**Subject: International Indoor Soccer Arena, 1311 Cuesta Arriba CT. NE,  
Albuquerque, New Mexico**

**Re: Responses to comment letter dated August 18, 2011**

**Re: International Indoor Soccer Area, 1311 Cuesta Arriba Ct. NE, Grading Plan  
Engineer's Stamp date 7-14-11 (D16/D00X)**

GRADING AND DRAINAGE PLAN

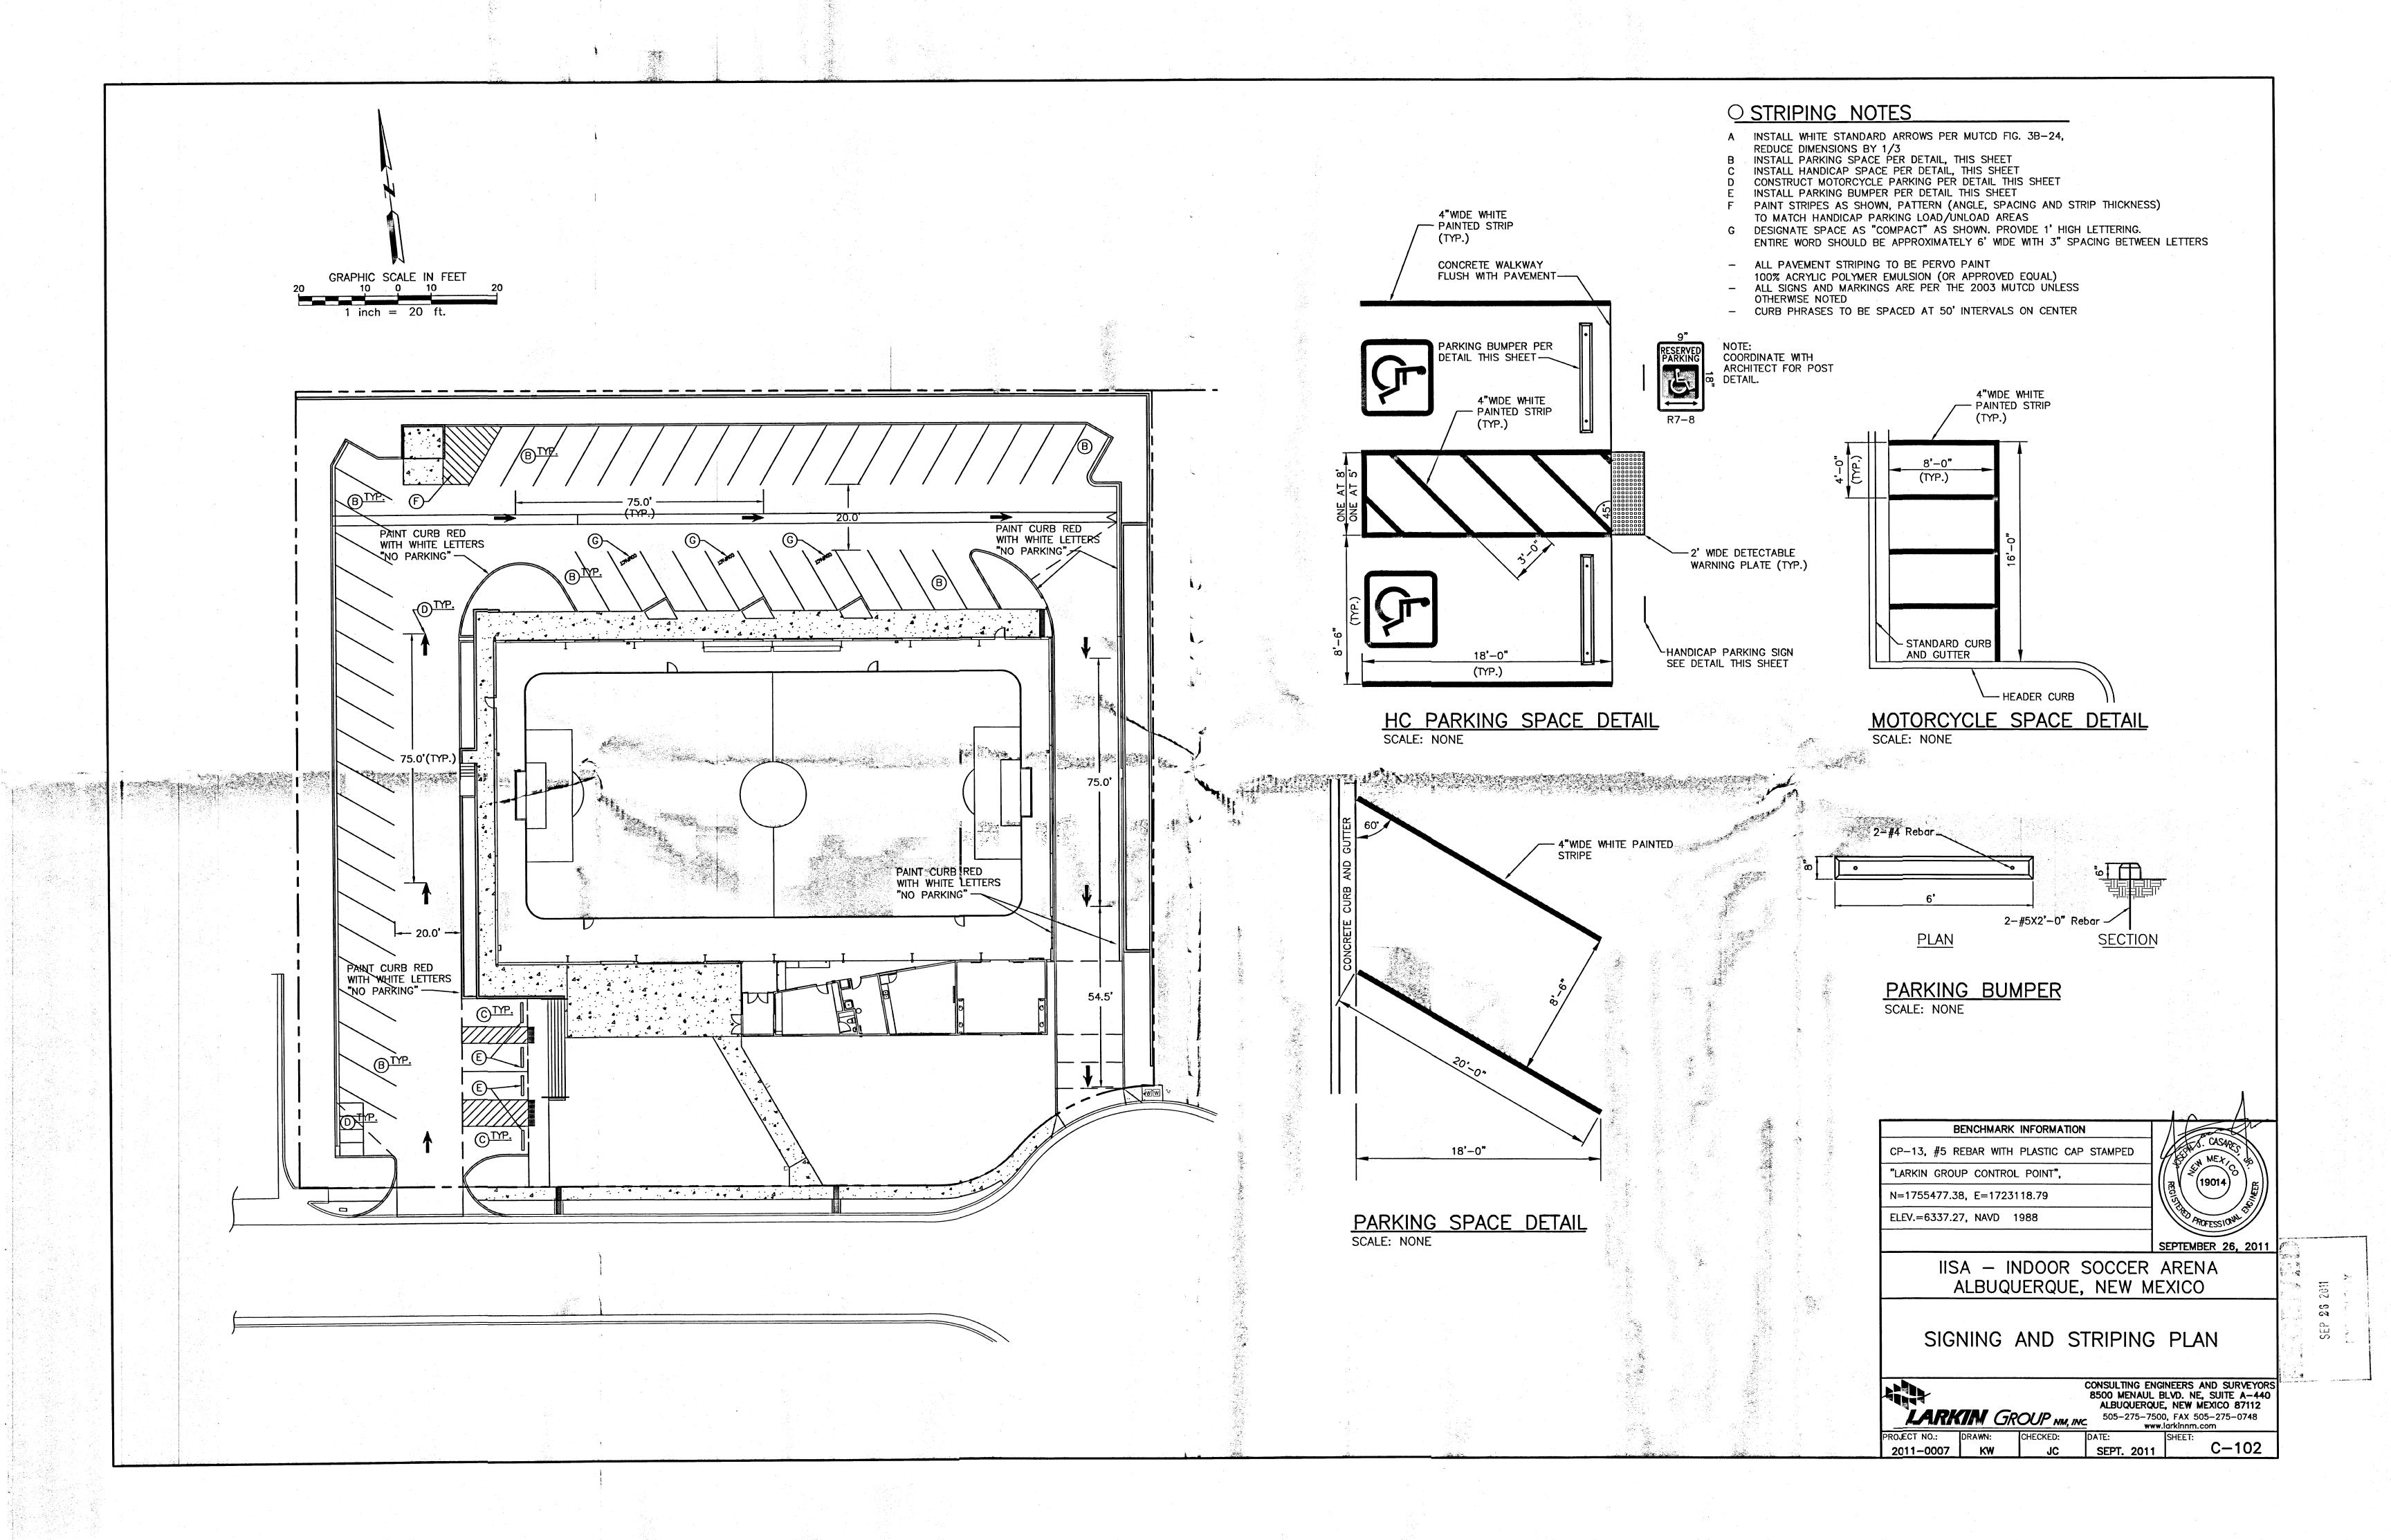
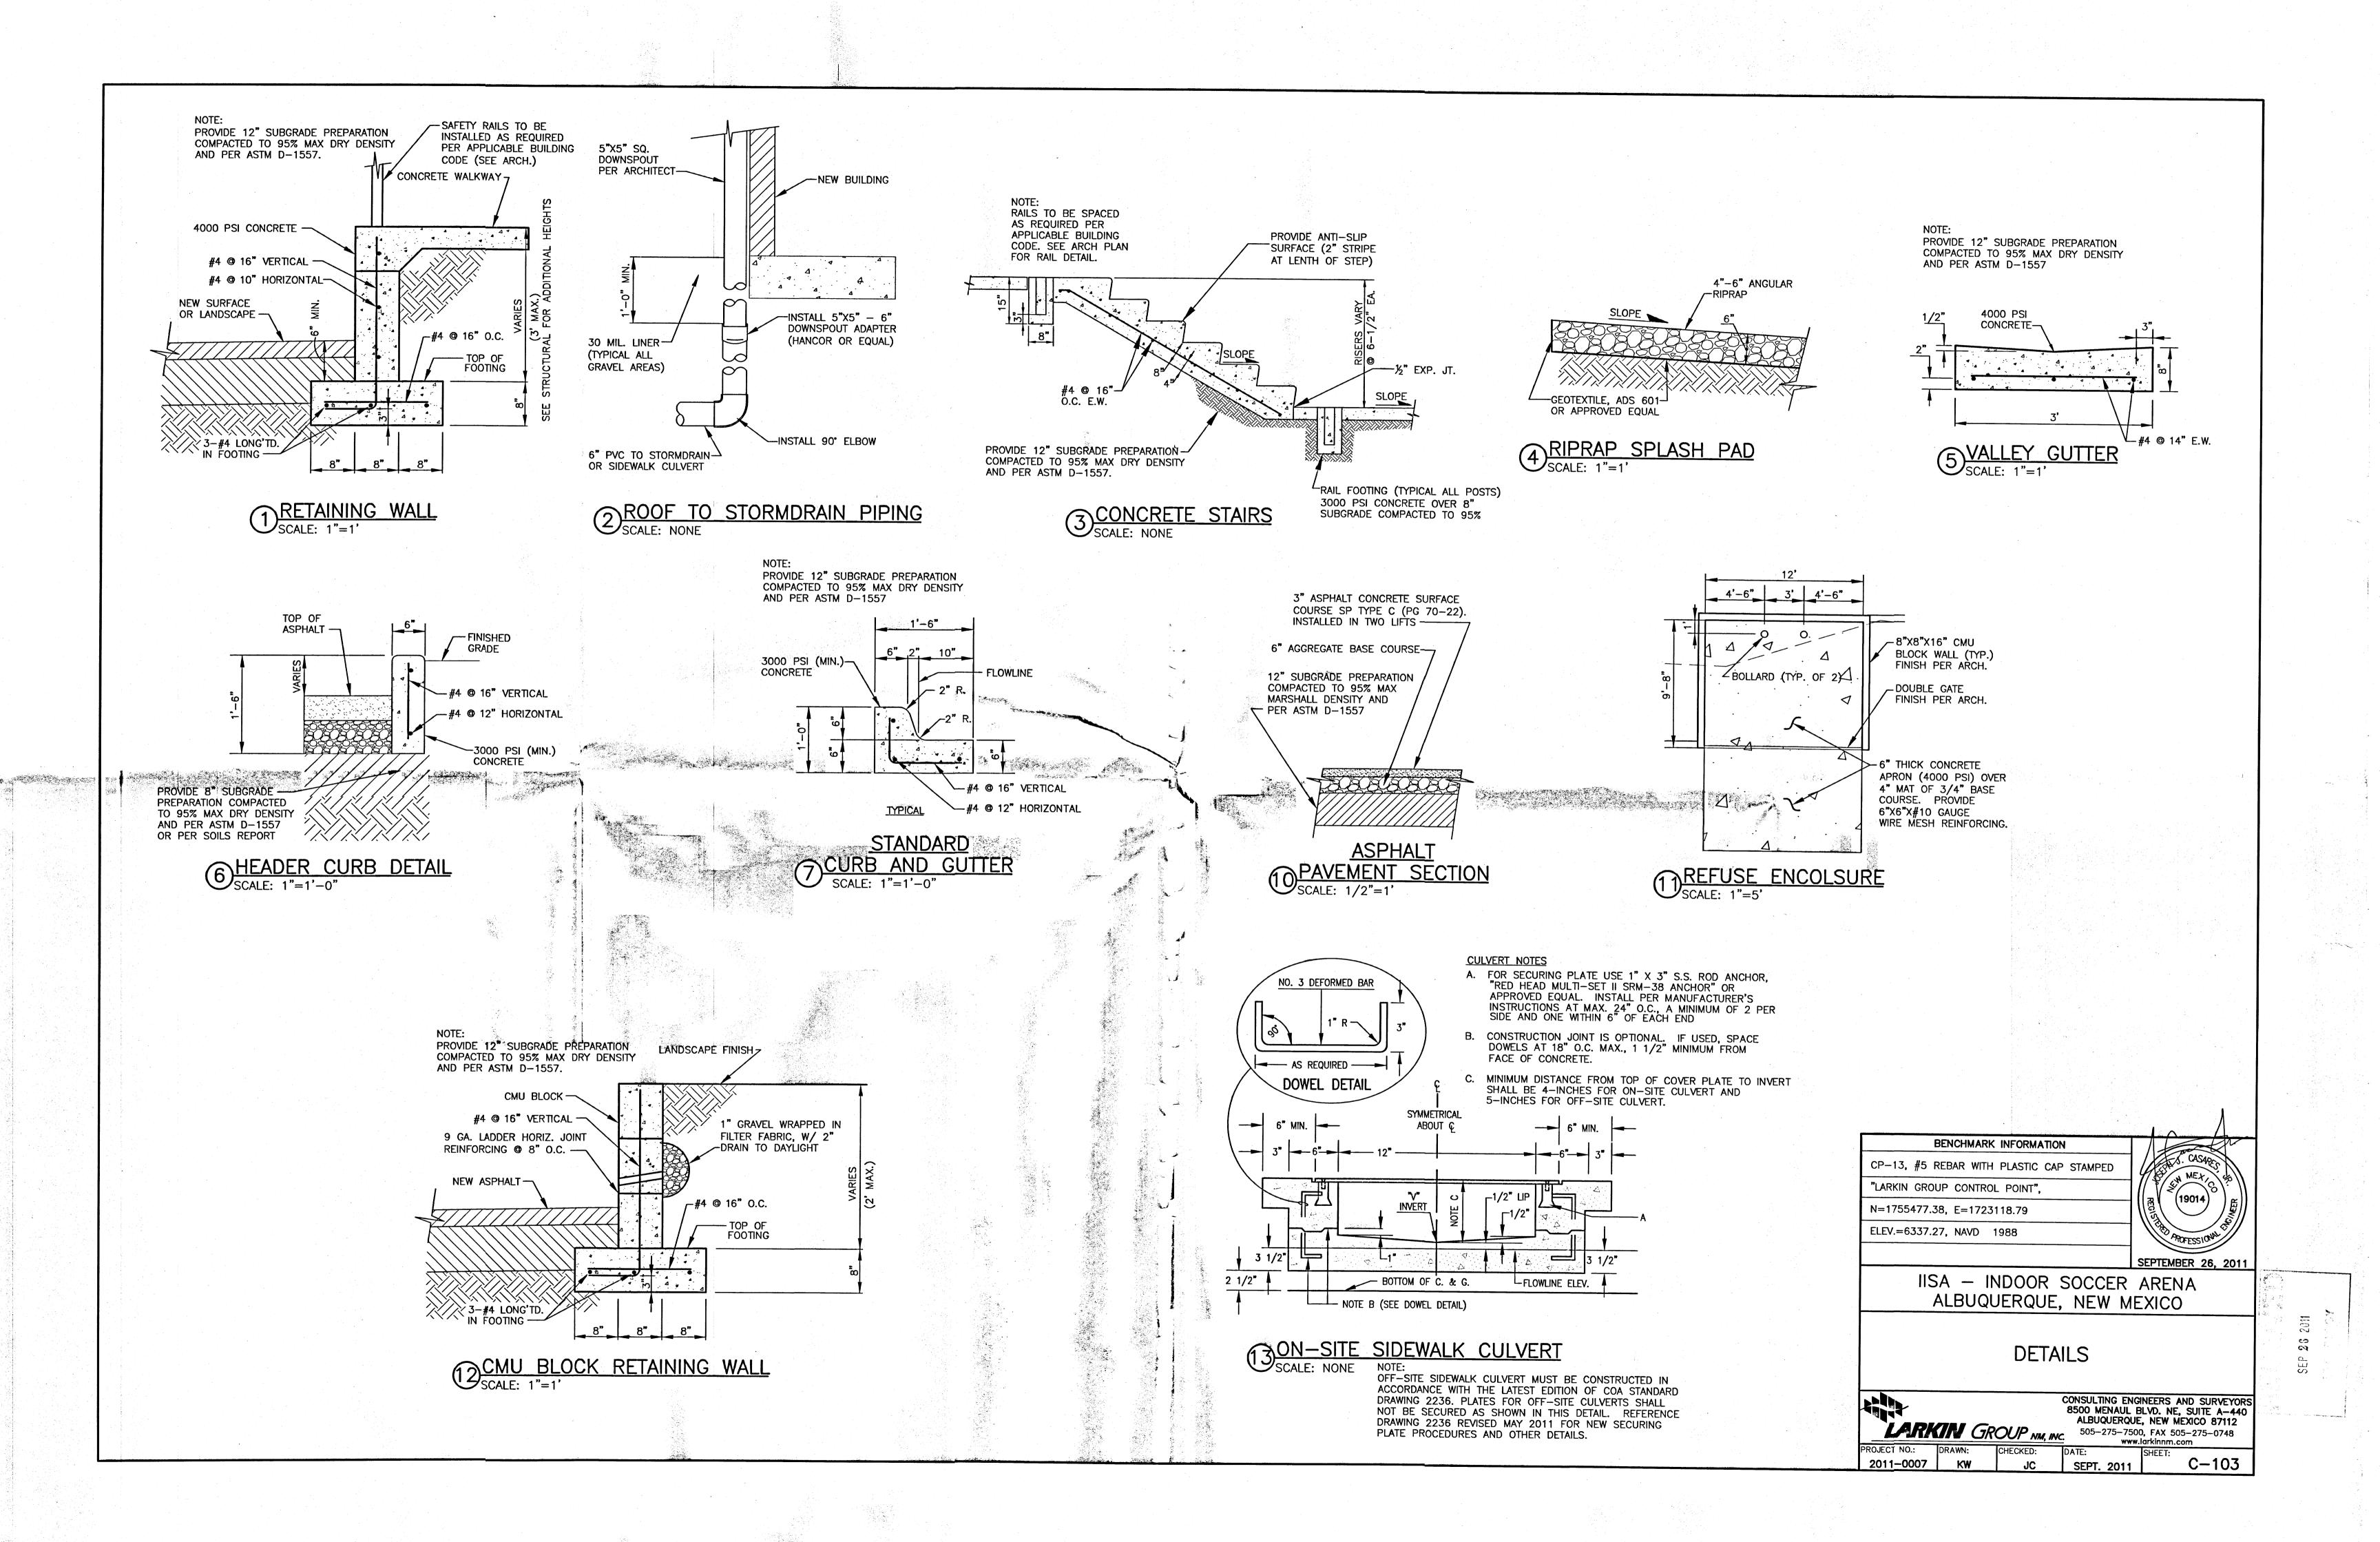
- Provide City Drainage file number and a copy of the plan where the allowable discharged is shown. *he has files*
  - Provide the total discharge from the site and make sure that it does not exceed the allowable discharge.

- Provide SO-19 construction notes and signature block for the construction of the sidewalk culvert.
  - Please use the attached revised copy of the sidewalk culvert on your plans.

- Extend the sidewalk culvert plate to the back of the curb.
  - Also use the orifice equation for sizing the sidewalk culvert.
  - Thicken the boundaries for drainage Section A, B, & C.

- Please provide spot elevations for the trash enclosure.
  - Please show parking spaces and handicap parking area.
  - Please show the door locations for the building.

- ✓ The landscaping along the westerly property line is draining out over the sidewalk. Please provide a sidewalk culvert, or route the runoff onto the paving area and out to the street through the entrance.
- ✓ See attached markups for additional comments.
- ✓ Hydrology is requesting that proposed landscape areas be depressed to retain/infiltrate the rain that falls on them.

- SO-19 construction notes and signature block now provided on sheet C-101.
- Sidewalk culverts within the ROW are now referenced to COA Standard Detail 2236, latest edition. On-site culverts are referenced to detail-13 shown on sheet C-103.

- Sidewalk culvert plate within the ROW has been extended to back of curb.
- Culverts calculations shown on sheet C-100 are now analyzed with the orifice equation.

- Boundaries shown on sheet C-100 for all areas are now thickened.
- Spot elevations for refuse area are now provided.

- Parking spaces and HC parking are now shown on sheet C-102.
- All door locations to the outside are now shown on sheet C-101.
- The runoff within the westerly landscaped area is now routed to the on-site pavement through a three foot curb cut (sheet C-101).
- All mark-ups and comments have been addressed.
- General note #24 on sheet C-101 now indicate all landscaped areas to be depressed approximately six inches
